From: Laura Gibbons <Laura.Gibbons@arun.gov.uk>
Sent: 13 July 2021 15:53
To: Planning.Responses <Planning.Responses@arun.gov.uk>
Cc: Maria Tomalova <Maria.Tomalova@arun.gov.uk>
Subject: RE: Planning Consultation on: Y/88/21/DOC

Application No: Y/88/21/DOC

Site Address: Pollards Nursery Lake Lane Barnham PO22 0AD

Description of Works: Approval of details reserved by condition imposed under ref Y/151/20/PL relating to Condition Nos 5 - surface waster drainage and 6 - discharge flows to watercourses, or for the culverting, diversion, infiling or obstruction of any watercourses

SITE LAYOUT
(1:200)

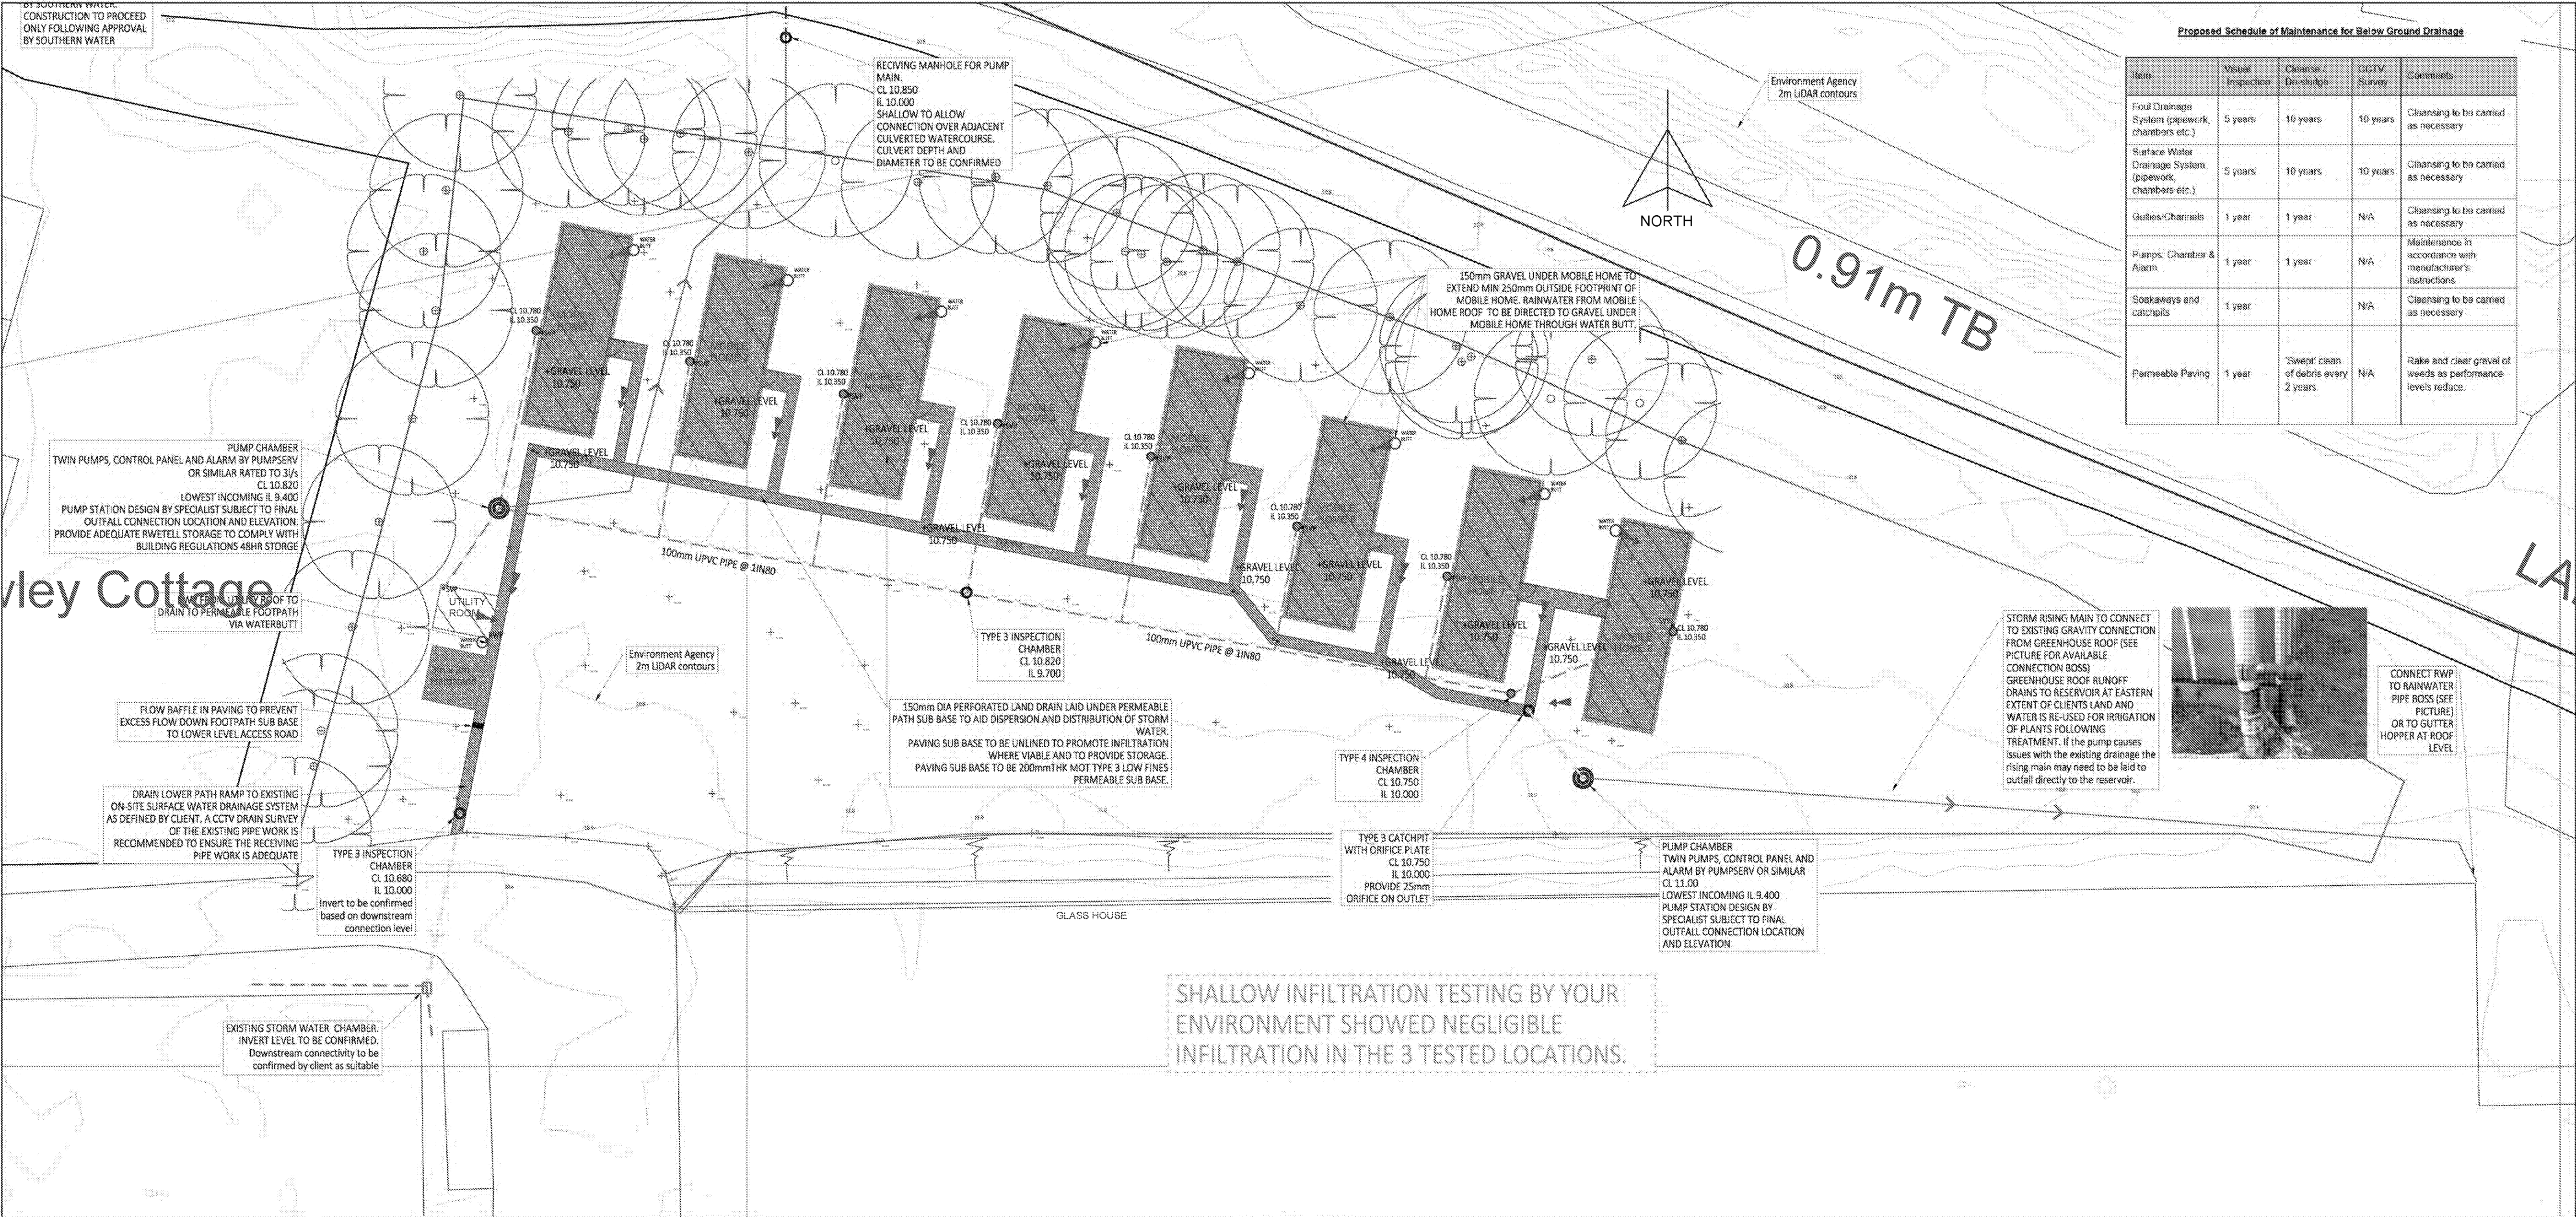
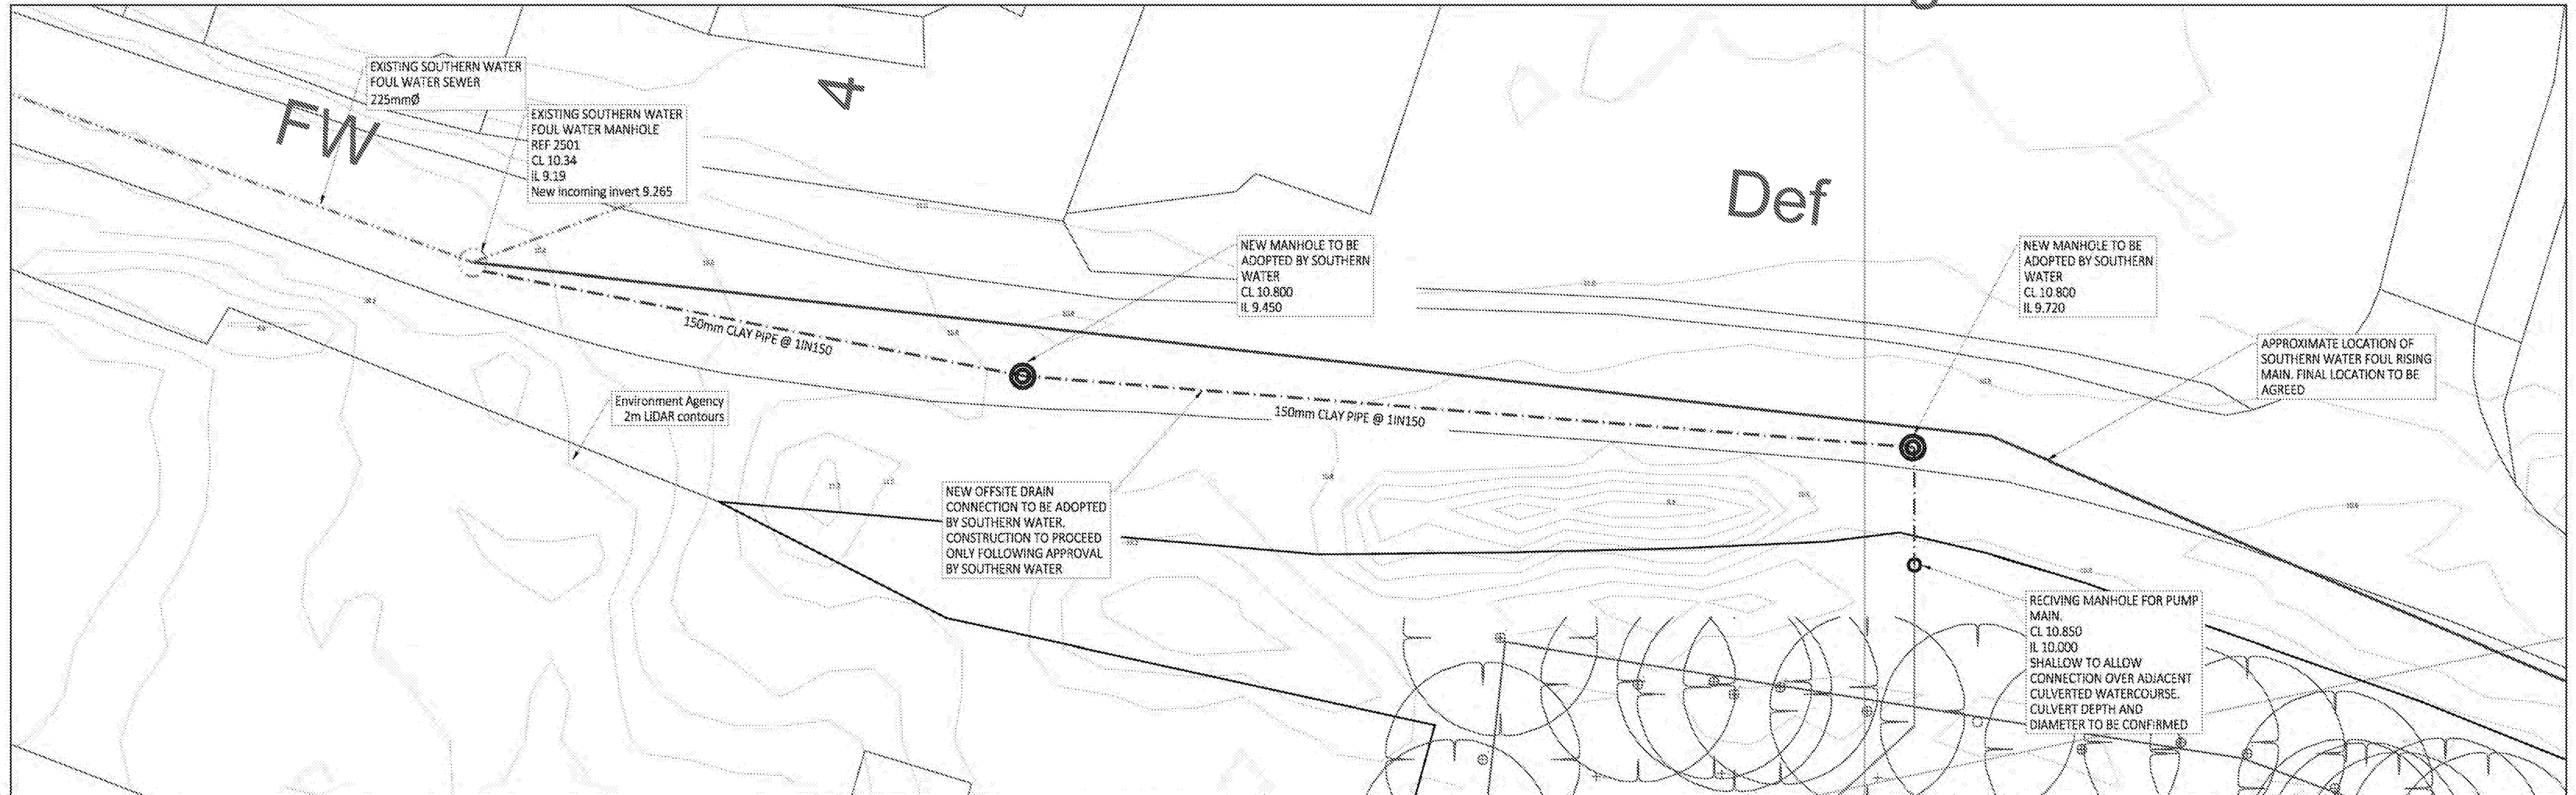
1. The applicant has completed summer infiltration testing which indicate infiltration is not viable.
2. No winter groundwater monitoring results have been provided, this information must be supplied to evidence that groundwater will not get into the surface water drainage system.

3. The proposal is for an unlined system to be pumped. This could in winter result in groundwater being pumped.
4. Pumping is not supported, it is not a sustainable solution. Pumps also fail and can result in increased flood risk both on and off site. The applicant must submit a revised gravity scheme.

5. The proposals are to pump surface water to the on site reservoir. The statement claims that no surface water will be discharged off site. No evidence has been submitted to evidence that either the existing surface water drainage network or reservoir have the capacity to accept these additional flows. The reservoir must also have an overflow to somewhere for water to be discharged in times of exceptional rainfall when irrigation demands are less, i.e. the winter. Therefore the statements provided are not supported by ourselves.

It is not possible for us to recommend discharge of this condition at this time with the strategy presented. A fully revised surface water drainage design is required, which may involve a gravity outfall to watercourse.
